**122 Anderson Street
Proposed Intermodal Facility for truck staging to load Nova Star Ferry
Level II Site Plan Review
#2014-112**

REPORT OF FINDINGS

August 15, 2014

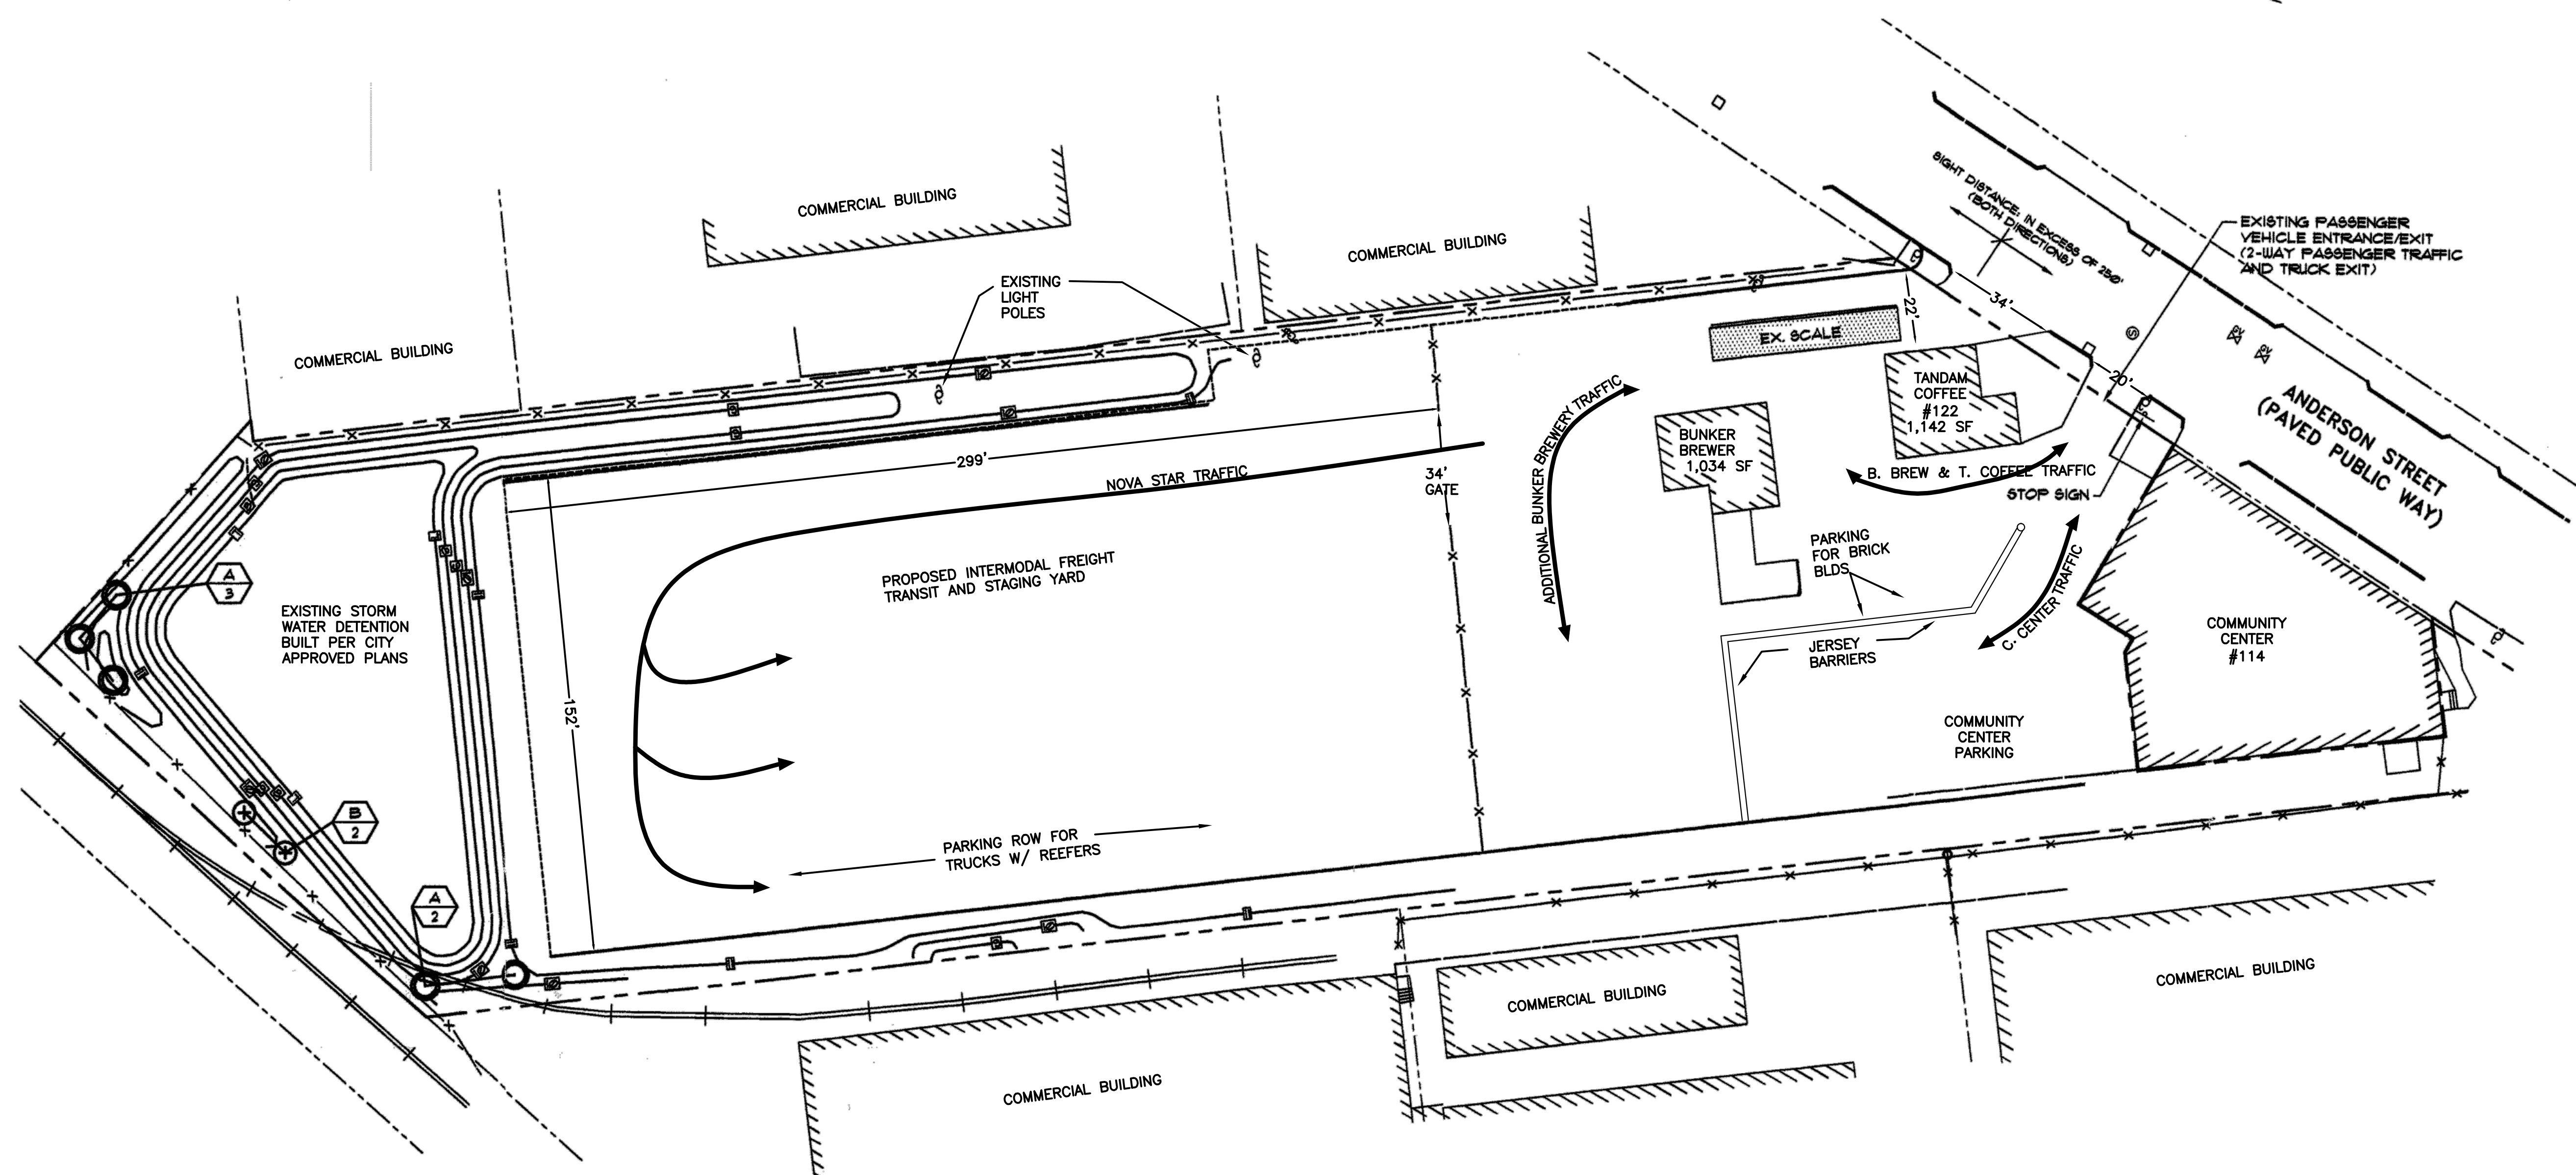
buildings. All vehicles with refrigeration equipment will line up at the furthest point from any residential zone (approximately 300'+ as shown on the submitted Site Plan). The access gate would be open at all times as currently is the case, so fire and security access would be available at all times.

Staff Findings: The trucks accessing the site to wait to load onto the Nova Star Ferry are proposed to use an identified access and egress point (the northerly drive), which staff consider is adequate subject to improvements in the surface, with added signage as outlined by Mr Errico (attached). Staff have also considered the spacing of existing access drives and support a waiver for the existing spacing, subject to the site plan conditions of approval.

Staff Findings: The proposed access route is angled from Anderson Street and this allows safe tractor trailer access into the drive. At present the drive does not meet the City standards and a condition of site plan approval has been included (based on the Traffic Engineers recommendations) to require upgrading:

- ▶ The applicant shall be responsible for providing a fully paved driveway of a minimum width of 22 feet wide from the right-of-way boundary extending into the site for 50 feet, prior to the commencement of the truck staging operation. A plan of this improvement shall be provided for review and approval prior to installation. The remainder of the site shall be maintained with a surface that does not allow the creation of dust. In addition, the applicant shall install truck entering warning signs at the site driveway that are compliant with the Manual on Uniform Traffic Control Devices, Federal Highway Administration. Final details of signs shall be reviewed and approved by the Planning Authority;
